November 06, 2023

N45 Architecture Inc.

**RE: First Technical Circulation Comments – Site Plan Control - 745 Smyth Road
Forestry:**

**1 SITE PLAN - NEW WORK**  
SCALE 1:325

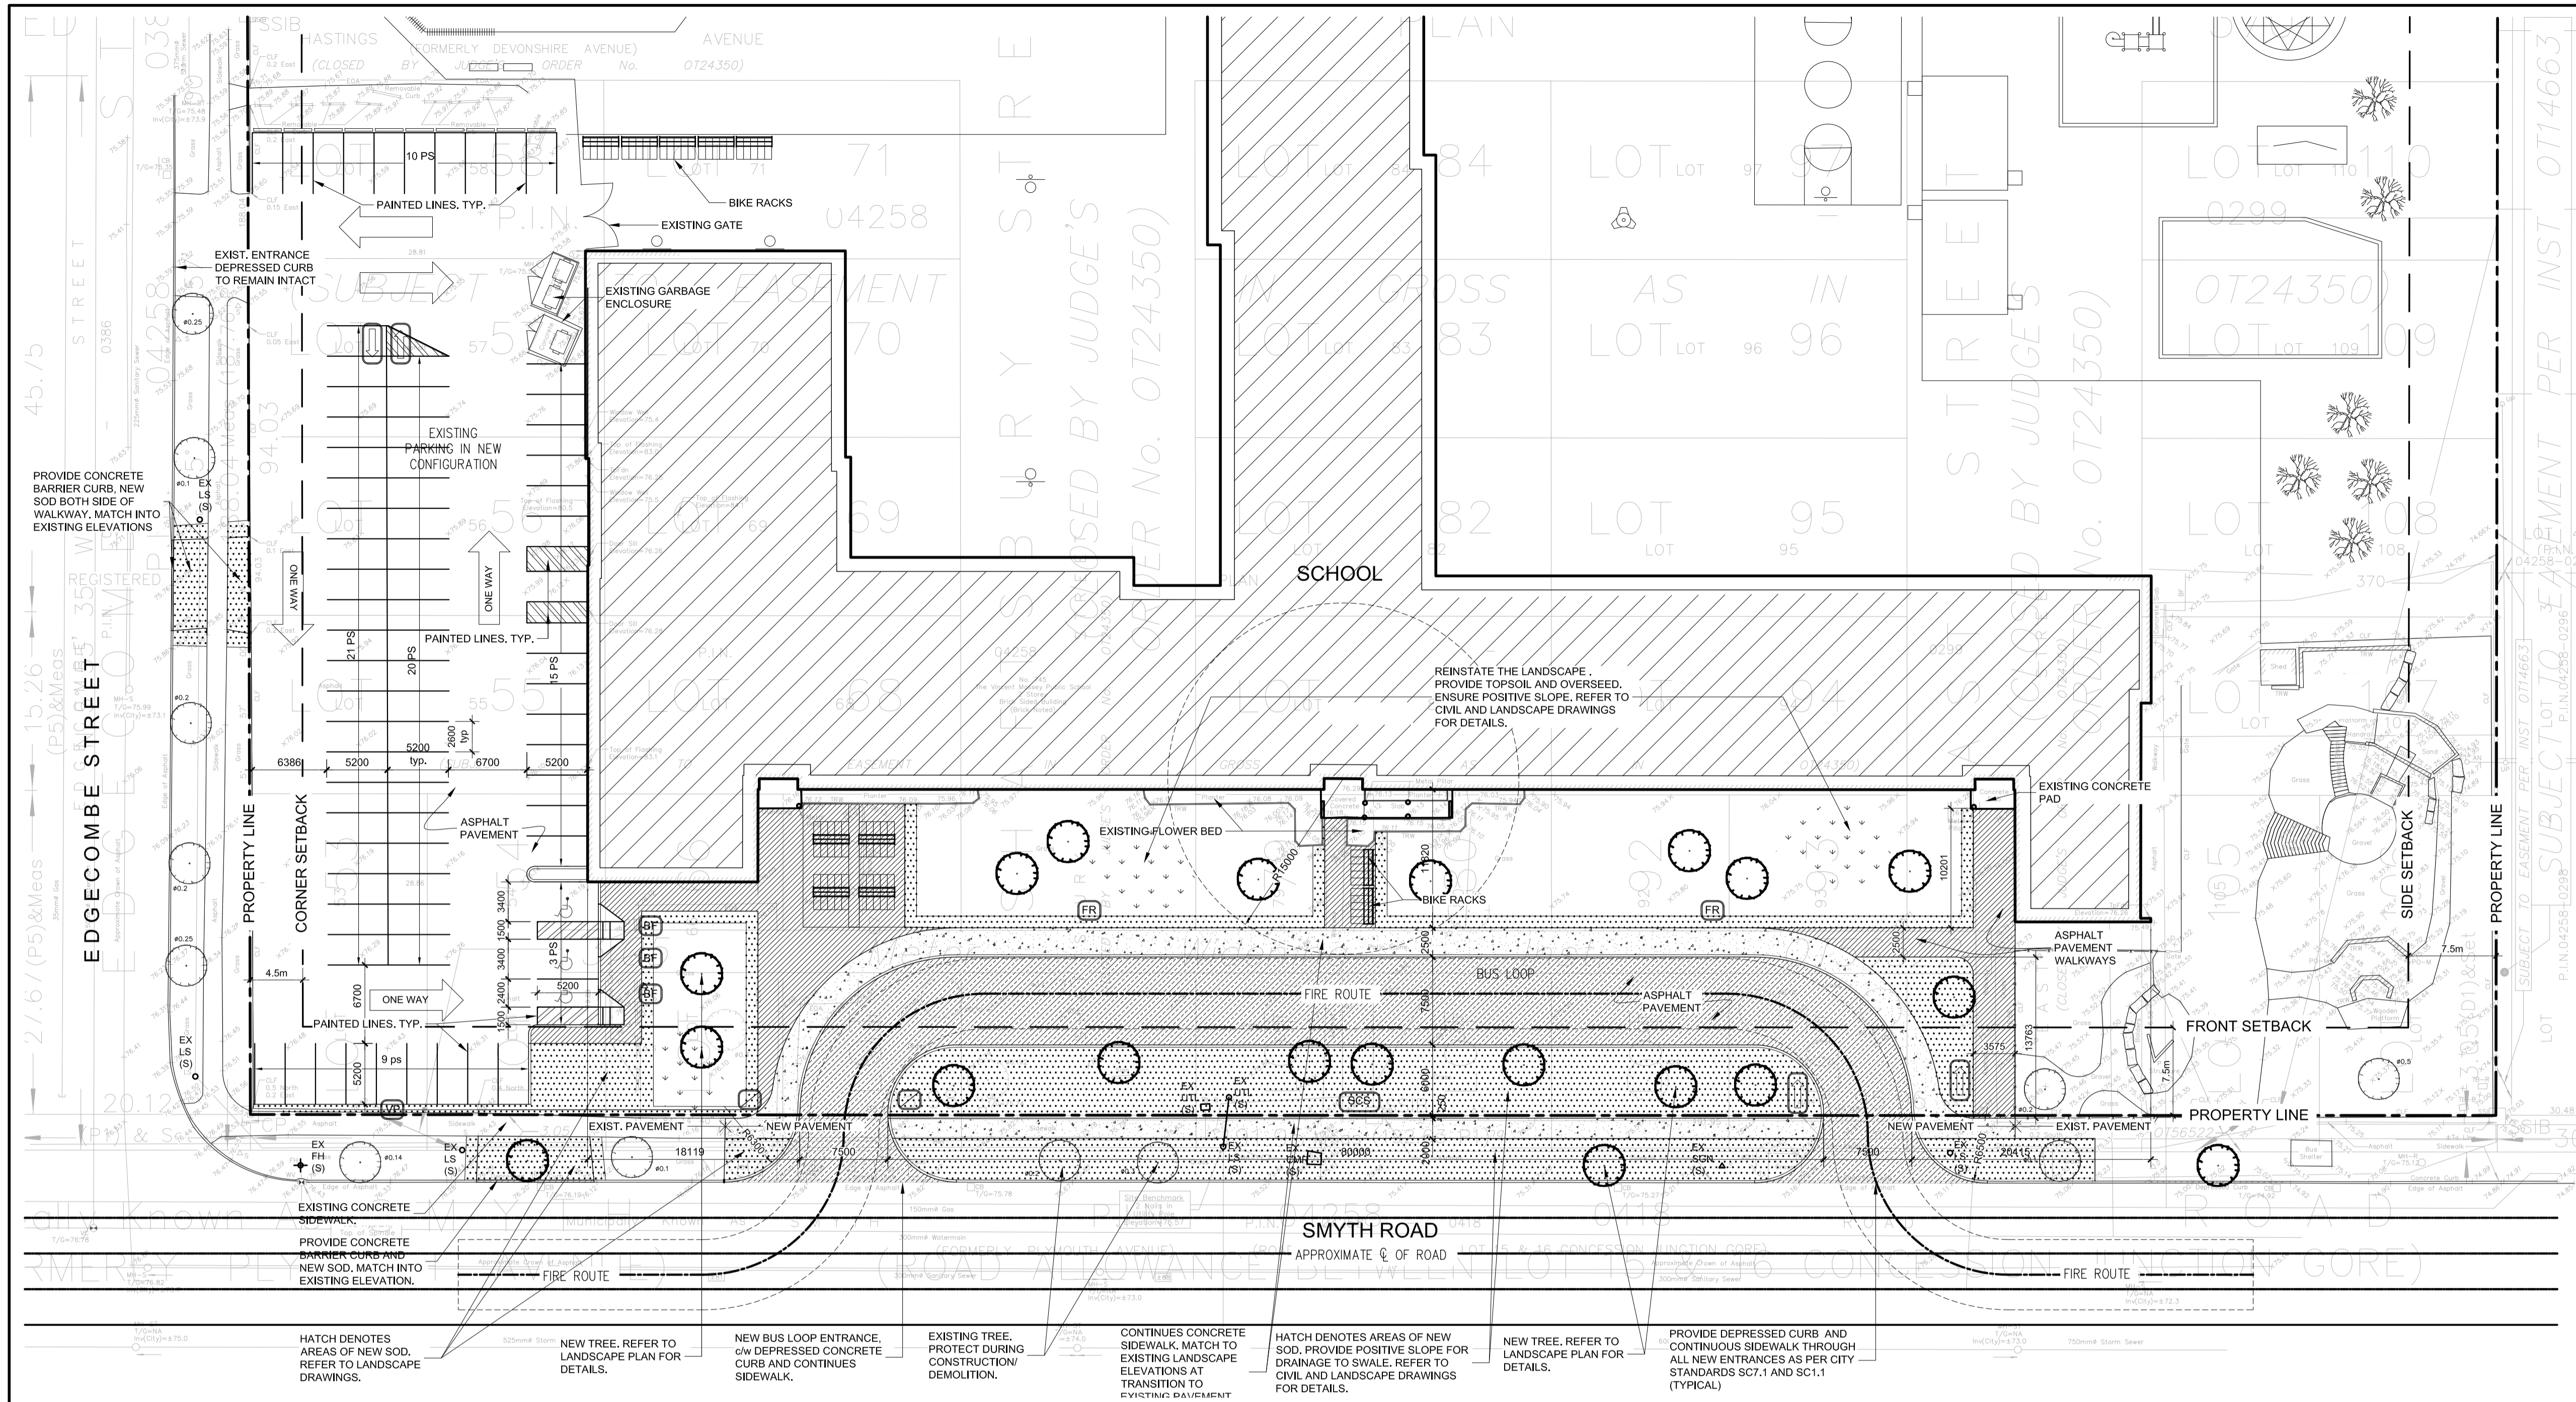
9. Please show where tree protection fencing, to the City of Ottawa's tree protection specification standards, will be installed.

10. Can tree #1, listed as being in poor condition, be removed and replaced?

11. Can a tree be added in the sodded area east of where tree #16 is currently? A tree is shown on the grading plan and site plan in this area.

12. Tree #7 is shown as to be retained on the plan but is listed as to be removed in the inventory table.

13. Can a tree be planted along Edgecombe where one of the access entrances will be removed and replaced with sod?

16. The immediate growing area around trees # 9 and 10 is currently sod. The LP doesn't show this area as sod. Is it being converted to pavement? The preference of the City would be to leave this area as soft scaping.

17. East of the speed camera, the extent of pavement extends from the edge of school property to the curb. Will there be a reinstatement of soft landscaping to provide a better suited growing environment for the two proposed 1-AsGM (soil volume area E)?

18. Please ensure there is no access conflict between the most eastern proposed tree and the access entrance to the play yard gate on Smyth or the 'school bus loading zone' sign with the proposed tree planting.

Tree Protection Fence outline added.

Yes, this tree is now shown as removed and replaced.

A tree has been shown on this location – 1 GtS.

Tree # 7 is shown as removed in both instances, it too close to the regrading in the island and will be highly impacted by construction.

Yes, one additional tree has been added in this location.

Hatching shown only where there is a change in surface or renewing surface, This area will remain as grass.

This area is shown as changed to soft landscape here (hard surface drop off area no longer required. Tree noted in comment #18 is also added here.

Tree location moved, see comment #17.
